LSC Responses to TIS Redline Comments

Falcon Storage Expansion Transportation Memorandum (LSC #S214430) August 12, 2021

AutoTurn Exhibits 1-4

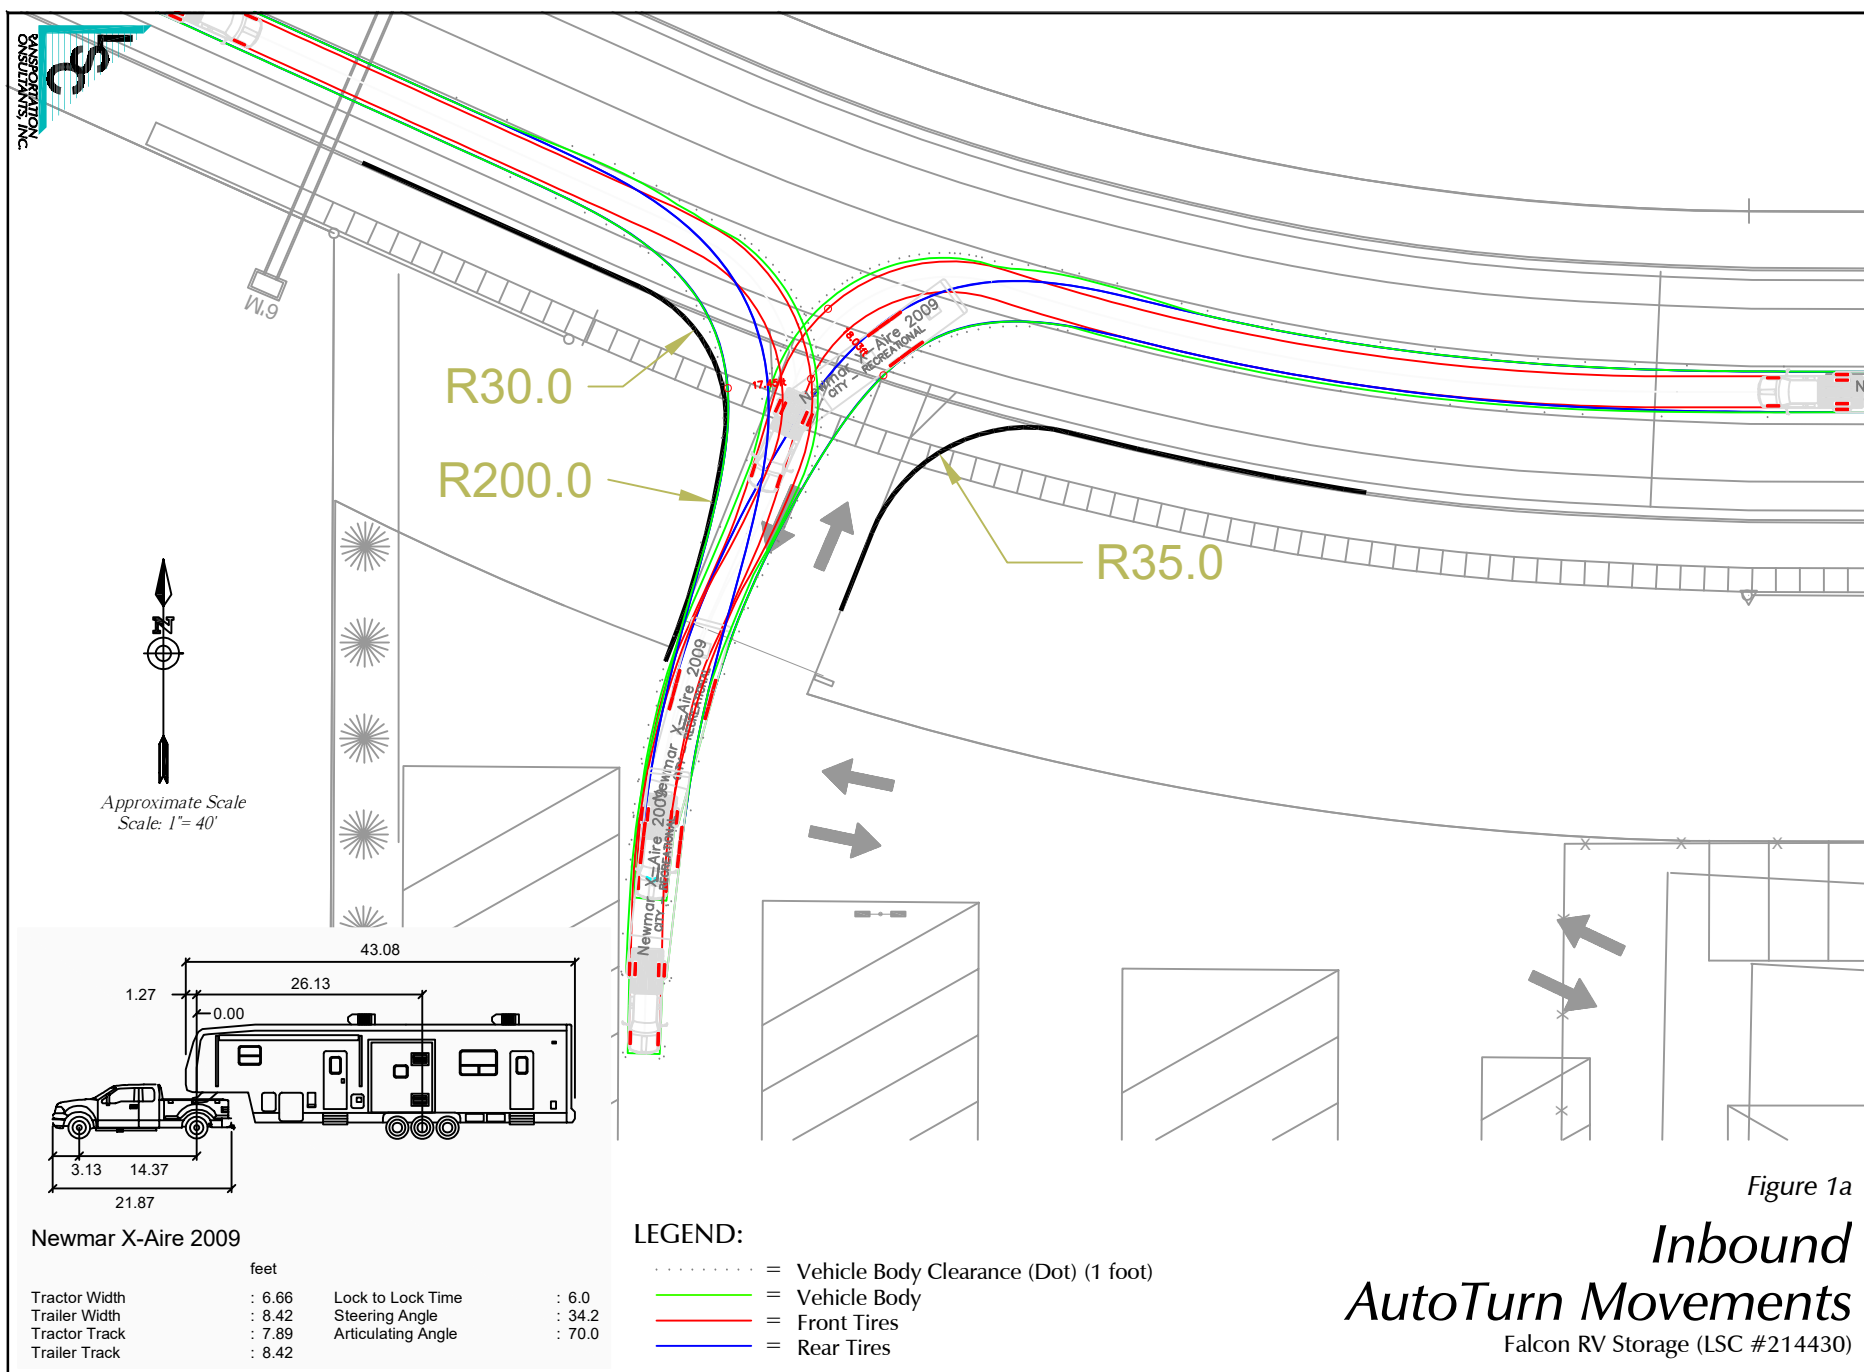
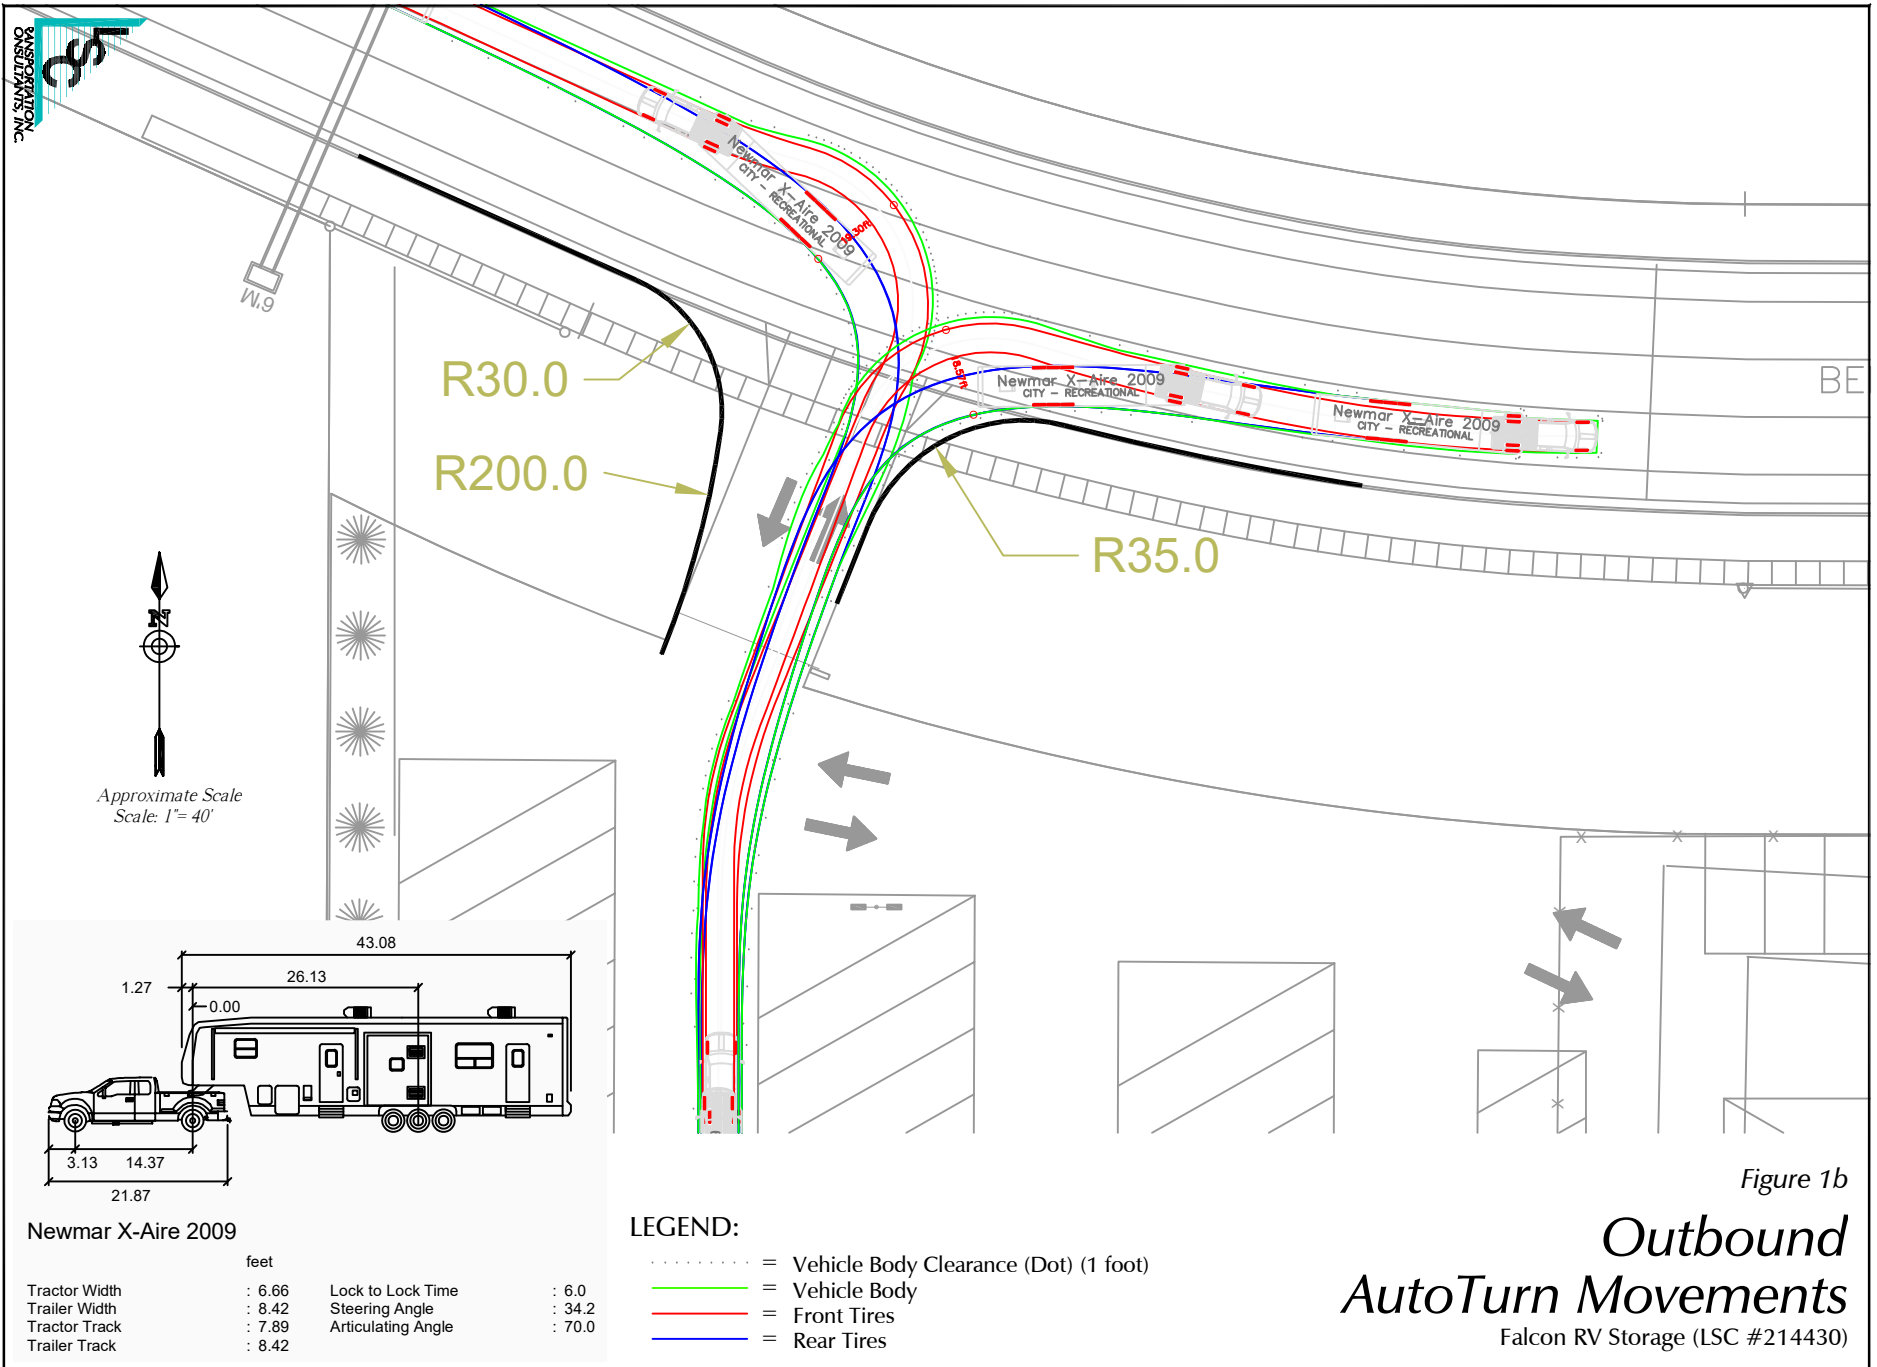
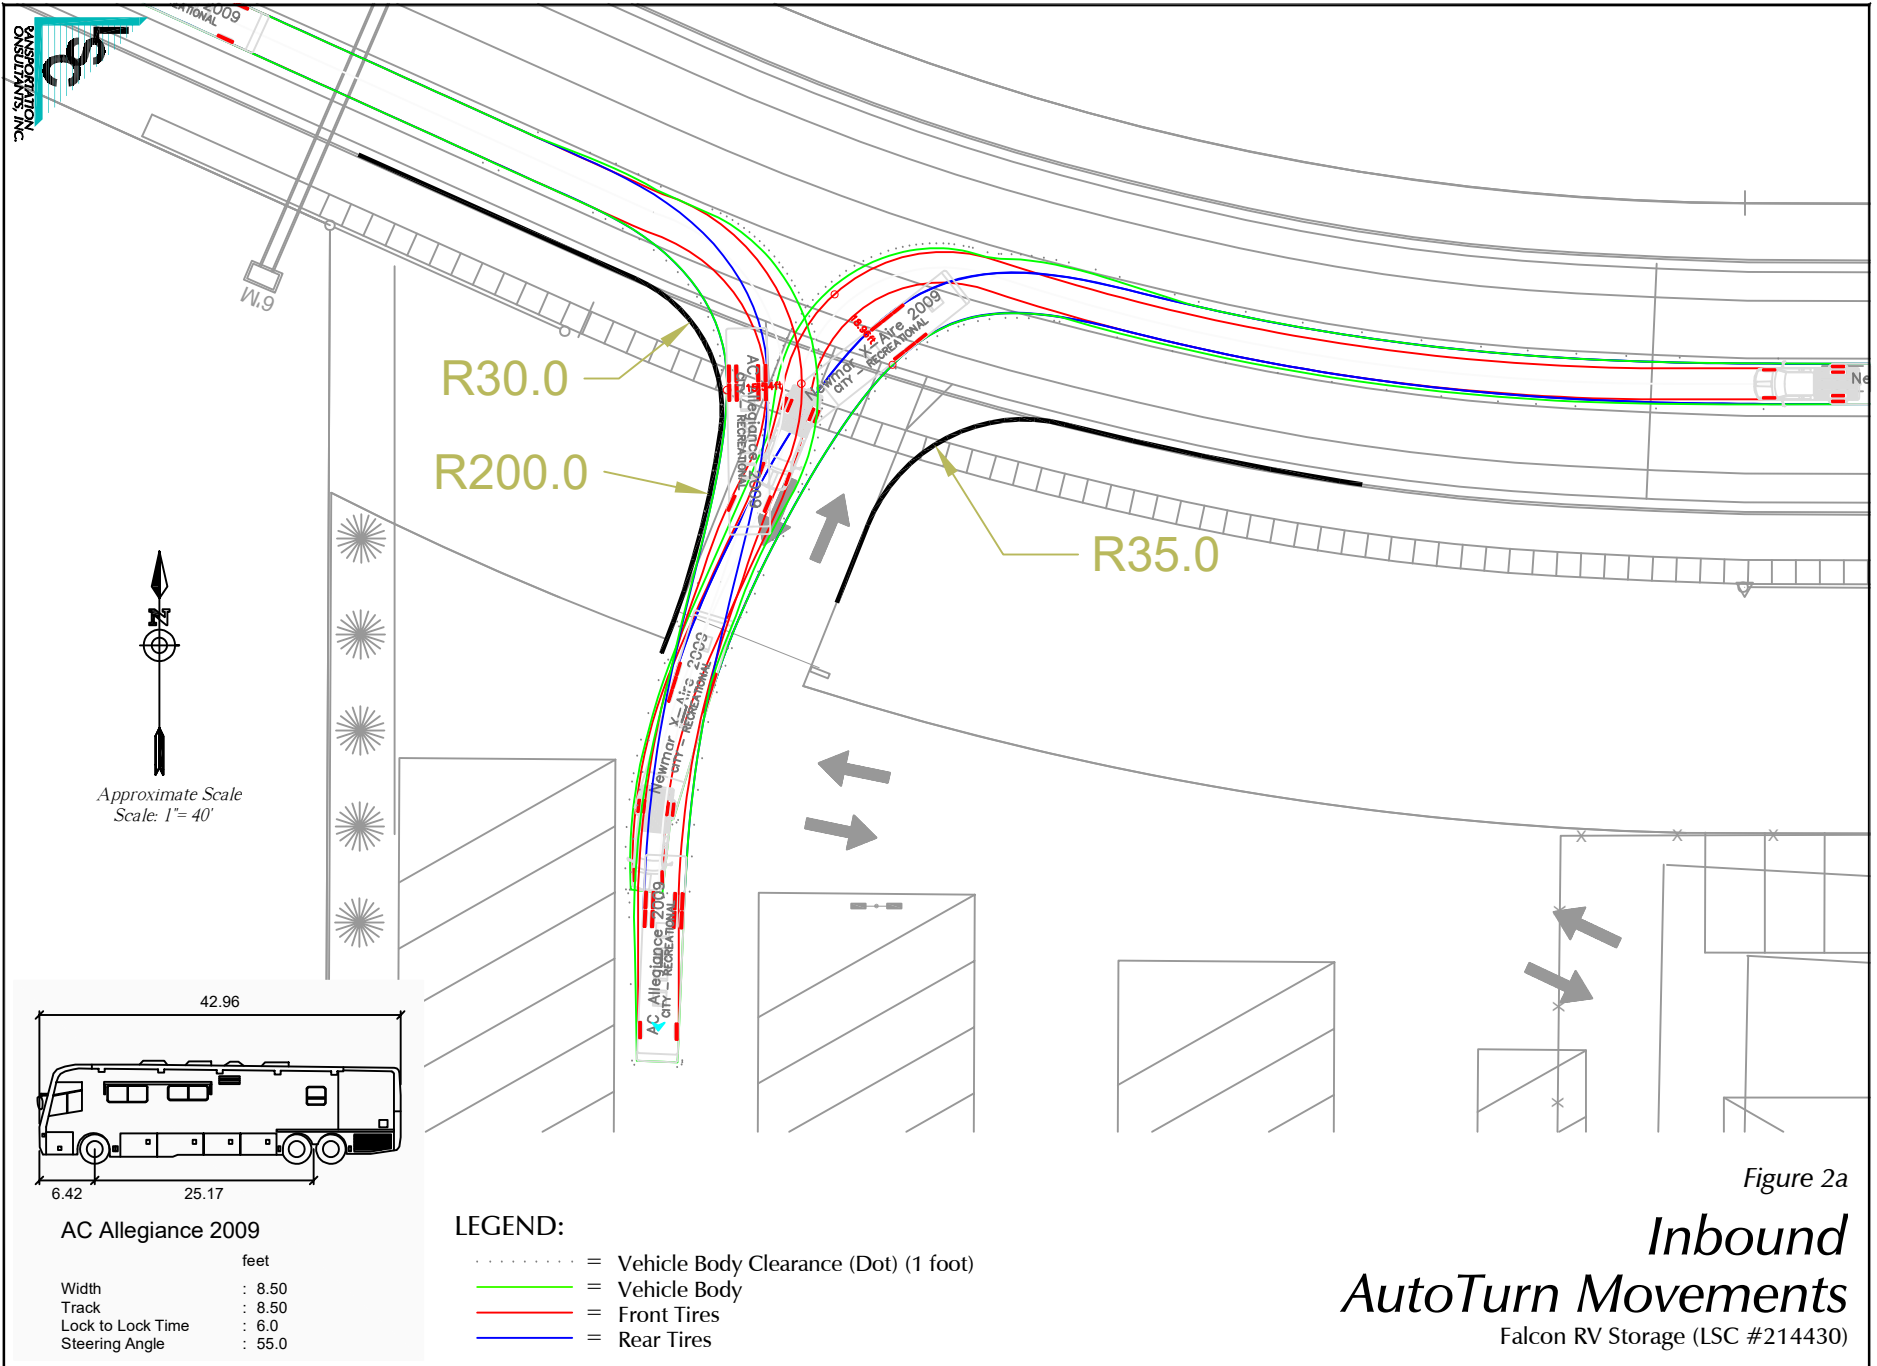
Please be sure to provide a truck turning exhibit for the proposed access and recommendations for the gate location to ensure sufficient queuing without blocking the road.

LSC Response: The AutoTurn analysis has been included in the updated report. The gate location recommendation is also included.
